Ribble Valley Borough Council
By email

Your ref 3/2026/0230
Our ref DC/26/1427
Date 30-JUL-26

Location: Land to the south of Ribblesdale Primary School west and north of Higher Standen Drive

Proposal: The erection of 60 dwellings comprising houses, bungalows, flats, related infrastructure (including public open space) and landscaping

Drawing file: planx_downloads / 26_0230_P26127DGCZ1GFDRC0001P05_Drainage_Strategy_Plan_5Aug26.pdf

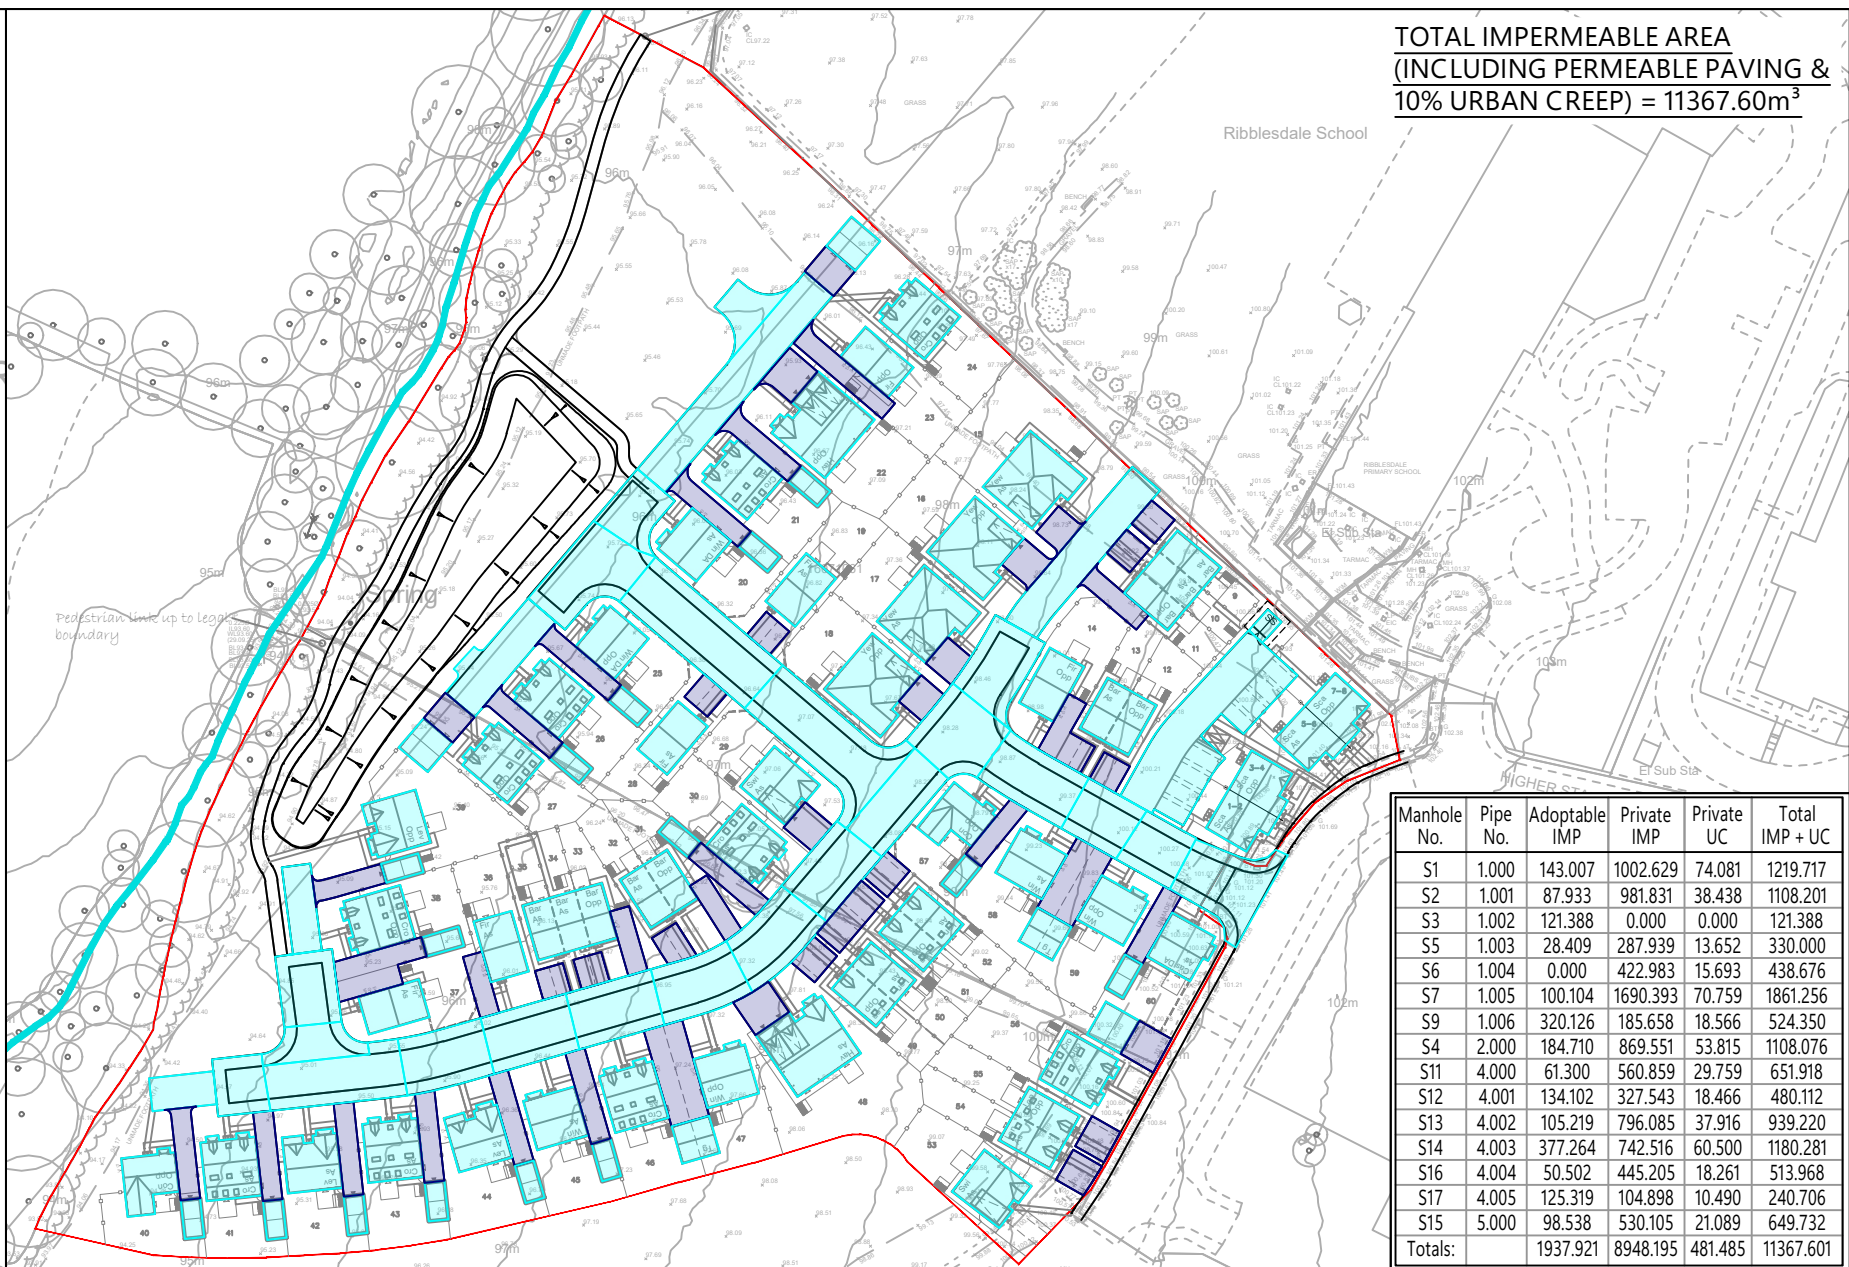
Following our review of the submitted Drainage Strategy, prepared by DCG, Ref: P26127-DGC-Z1-GF-DR-C-0001 Dated 07.07.2026, we can confirm that whilst the strategy for the disposal of foul and surface water is acceptable in principle, there are elements of the detailed drainage design that might not be acceptable to United Utilities and will require resolution by the applicant.

In particular this relates to the foul connection point. The foul connection point is to an unchartered/private sewer, please confirm where this discharges to the known network.

For this reason, and to avoid any unnecessary delays or costs for the applicant, we request that the proposed drainage strategy is not approved until such time as all concerns are resolved. The applicant should contact our Wastewater Developer Services team regarding this matter. See Appendix, Section 6.0 Contacts. Should planning permission be granted without resolution of all drainage concerns, we request the following condition is attached to any subsequent Decision Notice:
